**Addendum No. 1**

RE: Contract # C204107

**Cumberland County (U-4405)**

US-401 (Raeford Road) From Old Raeford Road To East  
Of Fairway Drive In Fayetteville

PROJECT REFERENCE NO. U-4405		SHEET NO. 6	
ROADWAY DESIGN ENGINEER		HYDRAULICS ENGINEER

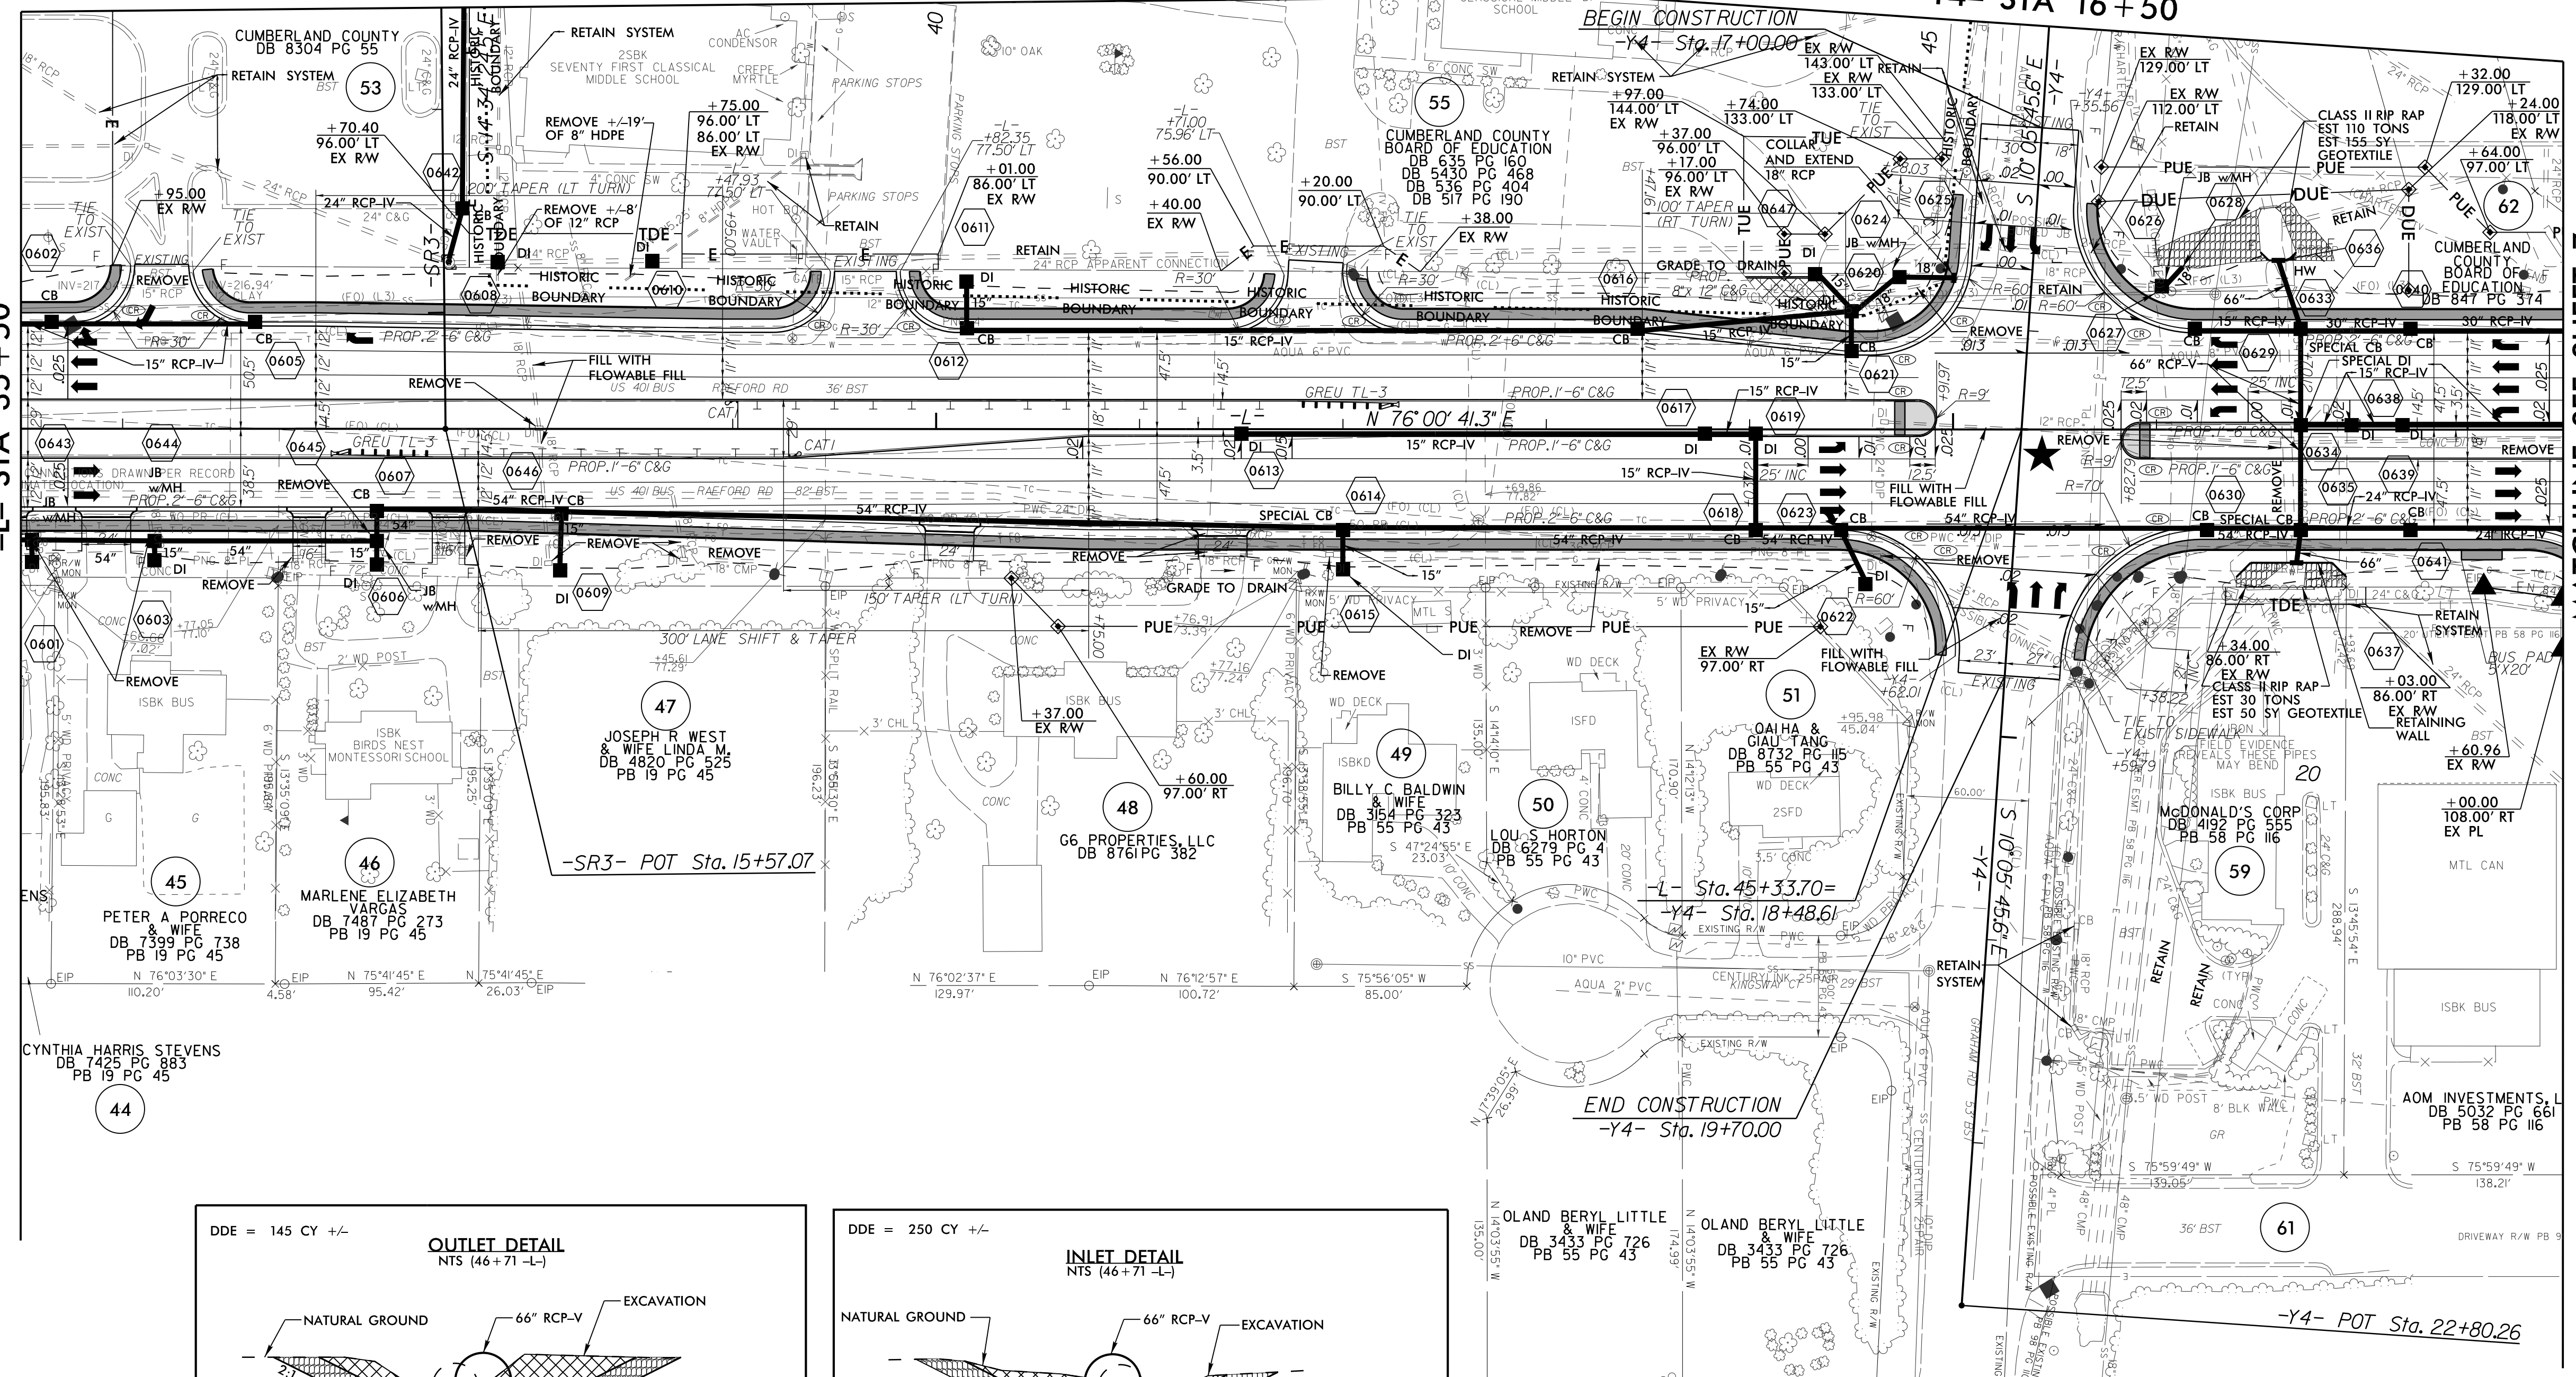
Sheet No.	Revisions
Title Sheet	Revised the letting date to August 21, 2018
3B-1	Revised Summary of Asphalt Pavement Removal
3D-41	Revised the quantity in the column for Concrete Pipe plug. Filled in drainage elbow quantities.
6	Added historic boundary at Parcel 55
17	Temporary Utility Easement was revised so as not to affect existing building
28	Added historic boundary and pavement removal at Parcel 55
